Shoalhaven Ethanol Plant Upgrade PHA

**Response to Department of Planning Comments
Concerning Hazards**

**GHD Pty Ltd
October 2008**

**Shoalhaven Ethanol Plant Upgrade PHA
Response to DoP Comments**

Figure 1 | Location of Co-generation Plant (red shading)

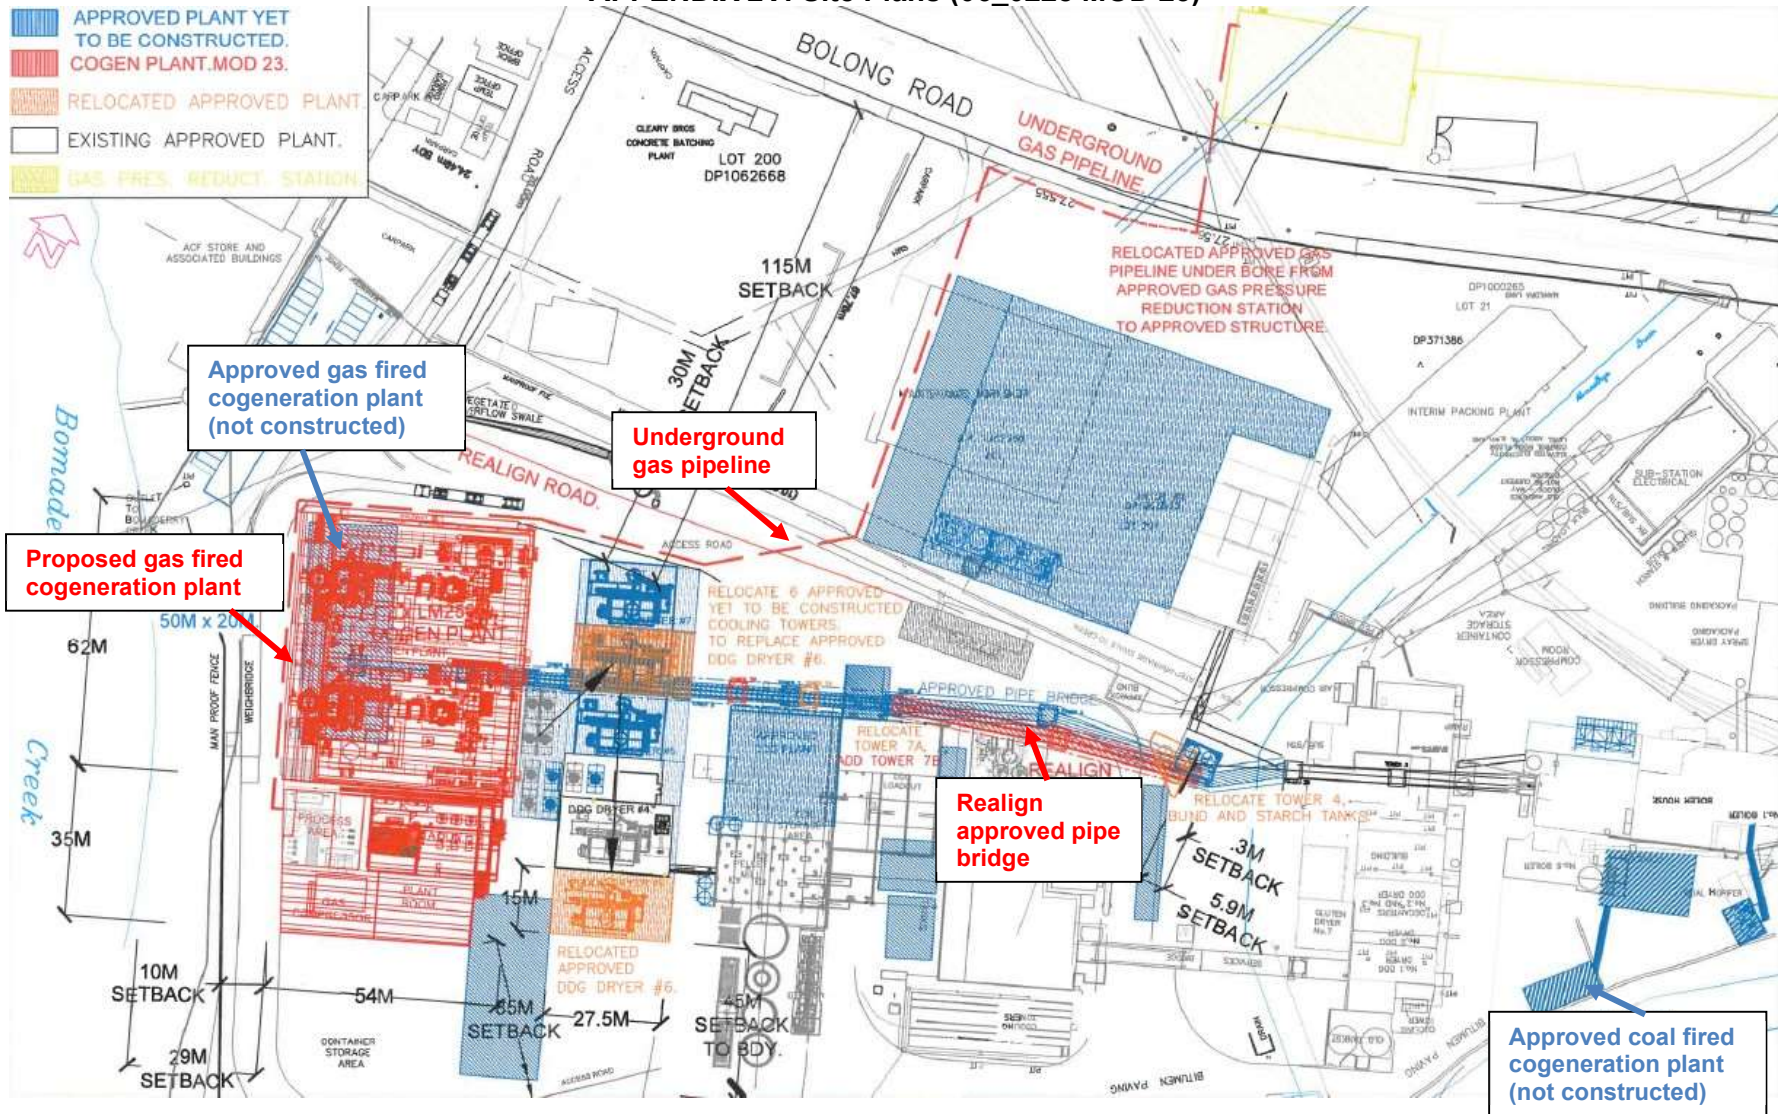
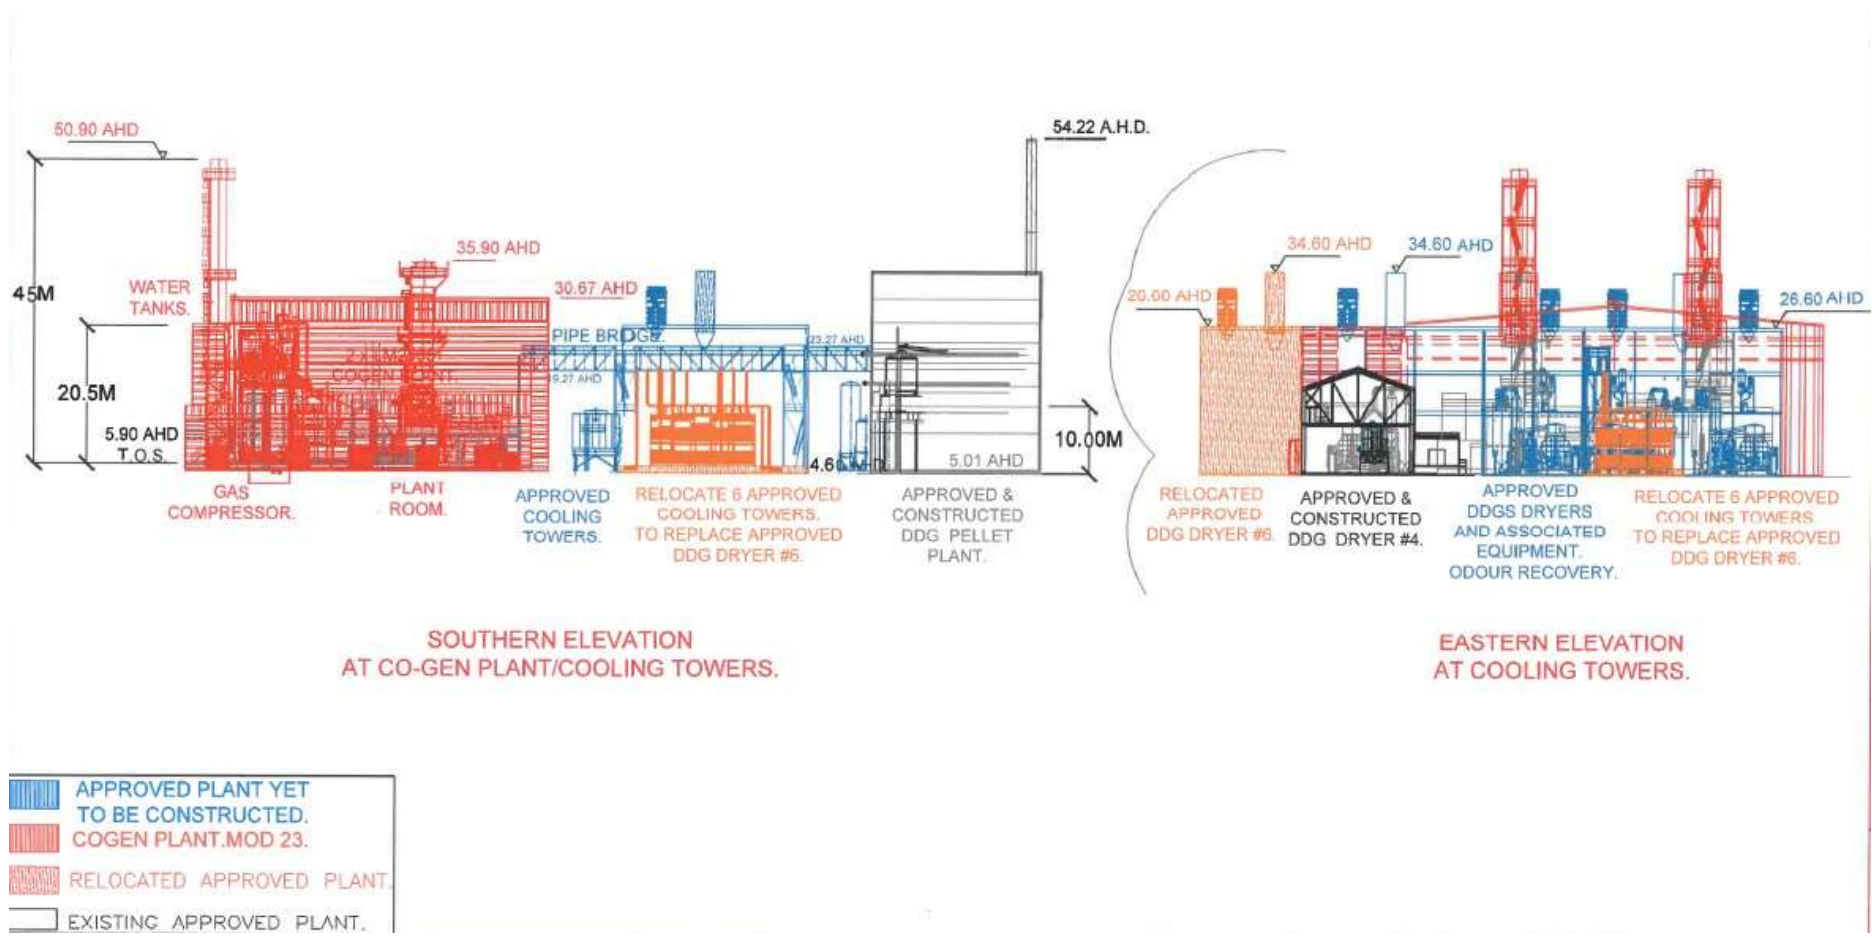
6. **Table C2 shows a confined strength of 5 for the cogen plant. The cogen plant will be inside a building (mostly for noise reduction purposes). Any mitigating measures such as blast panels etc should be discussed to justify using a confined strength of 5.**

A higher confined strength (for example using 8) still does not increase the nominated risk beyond the site boundary.

Protection measures against fire and explosion, such as blast panels etc , in the co-generation plant to be considered by Manildra in the detail design phase of the project and other safety studies (e.g. HAZOP study).
